**KIRKLEES METROPOLITAN COUNCIL  
INVESTMENT & REGENERATION SERVICE**

**Reference No:** 2021/62/92368/E

**Site Address:** 36, Hopton Lane, Mirfield, WF14 8JU

**Description:** Erection of single storey front and side extension,  
dormer window to front and associated alterations

Client		Mr & Mrs Hoyle					
Job		36 Hopton Lane Mirfield					
Title		Proposed Right Side Elevation					
Drawn By	RK	Date	May 2021				
Eng. Check		Scale	1:50				
Tech. Check							
Drawing No.		Rev.					
2021 / 305 / 04		<table><tr><td></td><td></td></tr><tr><td></td><td></td></tr></table>

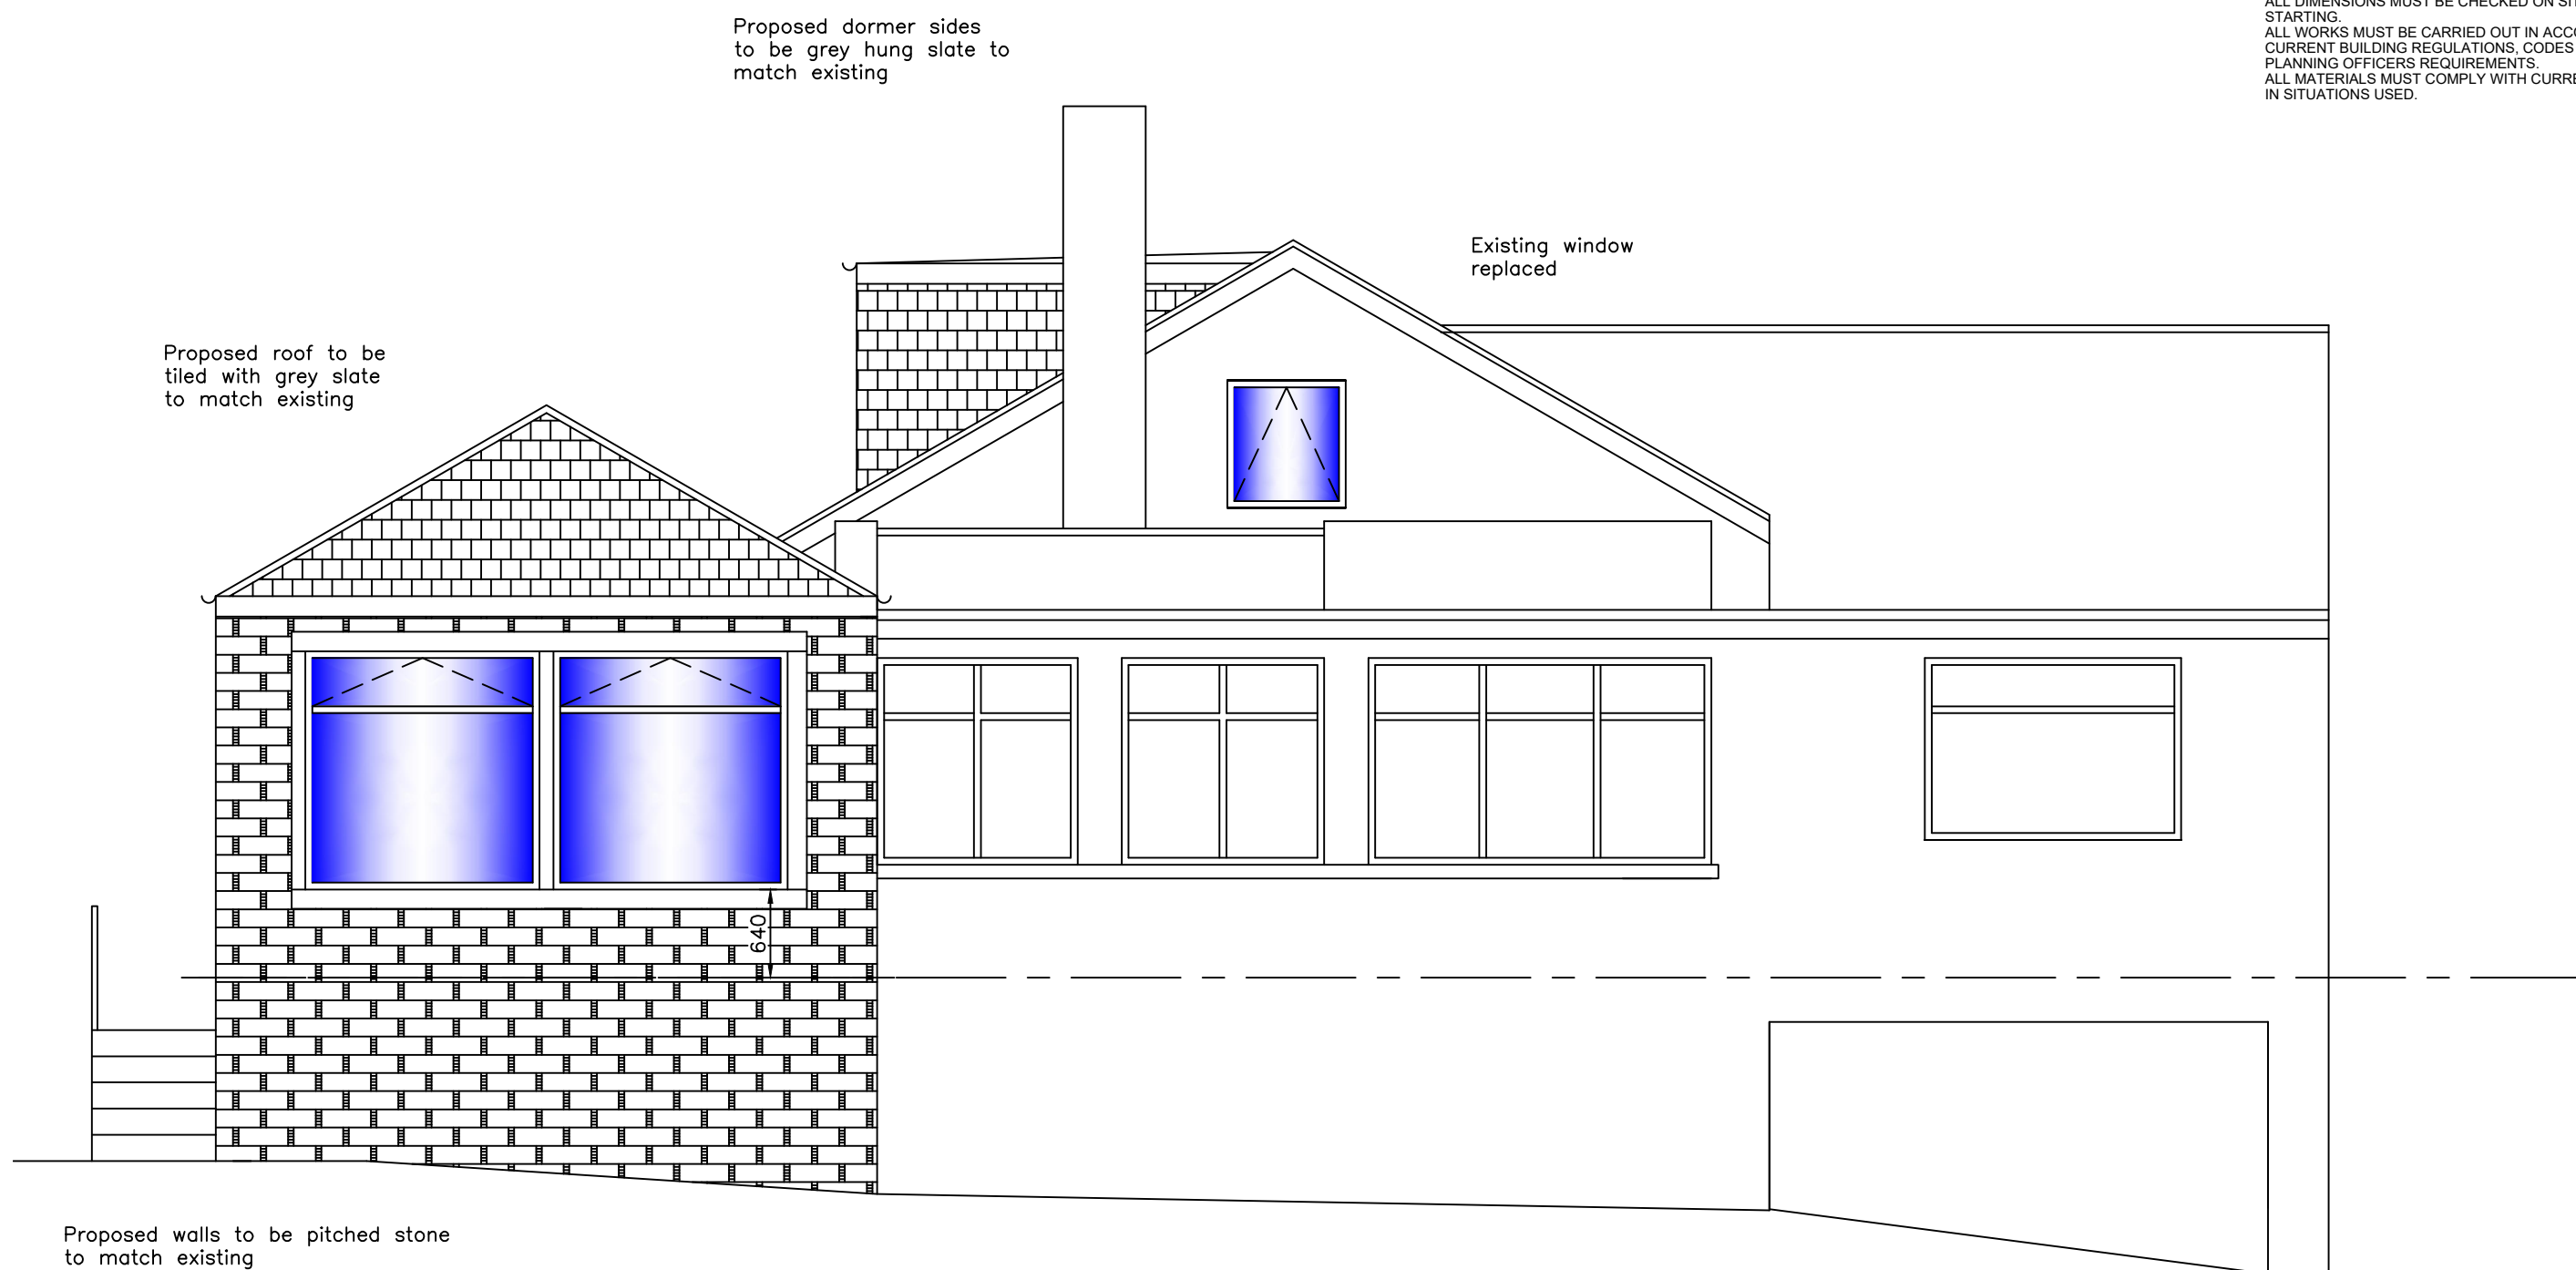
The proposed extension would project by 2.5 metres towards the shared boundary with 34 Hopton Lane, which is set down significantly from the application site. There would remain 0.9 metres between the proposed extension and the shared boundary. This neighbouring house is set forward from the host dwelling and, therefore, the proposed extension would be adjacent to this neighbouring property's flat roof. It is, therefore, considered that the proposed would not cause any significant overshadowing or overbearing impact to this neighbouring property.

There would be additional windows proposed in the side elevation adjacent to 34 Hopton Lane, which is considered acceptable in this instance, as they would overlook the neighbouring property's flat roof and given the existing windows on the eastern side elevation of 36 Hopton Lane, it is considered that the proposal would not cause significant additional overlooking harm.

Client		Mr & Mrs Hoyle	
Job		36 Hopton Lane Mirfield	
Title		Proposed Rear & Side Elevation	
Drawn By	RK	Date	May 2021
Eng. Check		Scale	1:50
Tech. Check			
Drawing No.		Rev.	
2021 / 305 / 05

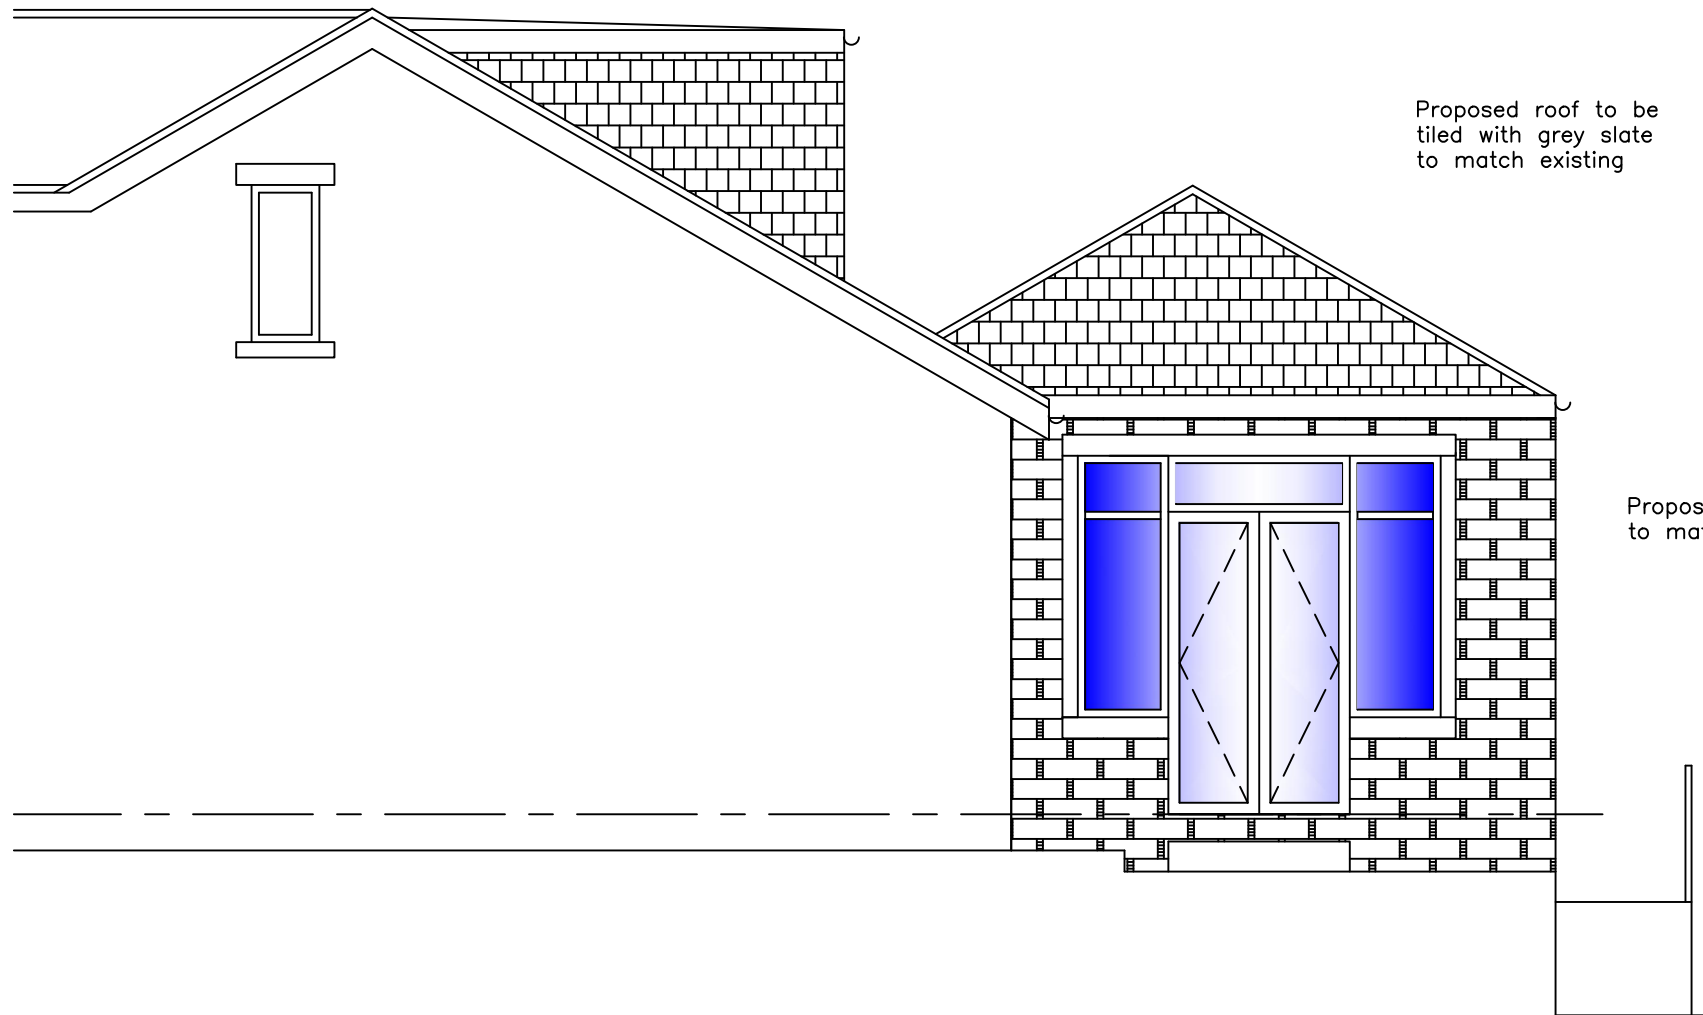
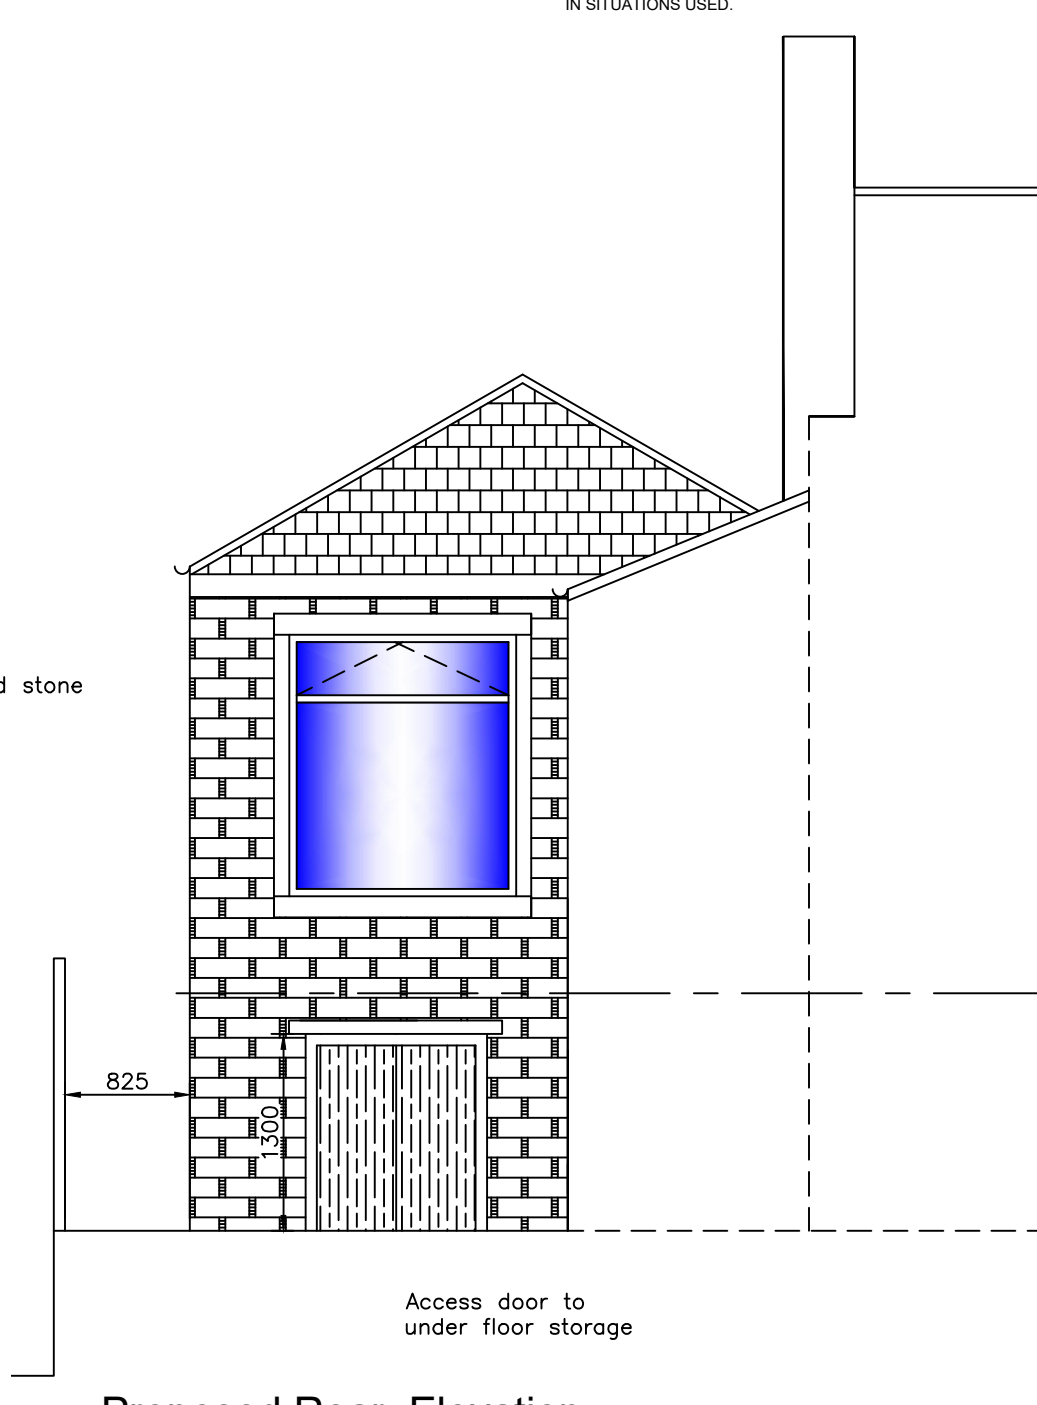
4. The external walls of the proposed dormer window shall be finished in hung grey slate to match the existing and "grey slate UPVC panels" as demonstrated in the approved plans "2021/305/03" and "2021/305/05" and thereafter retained.
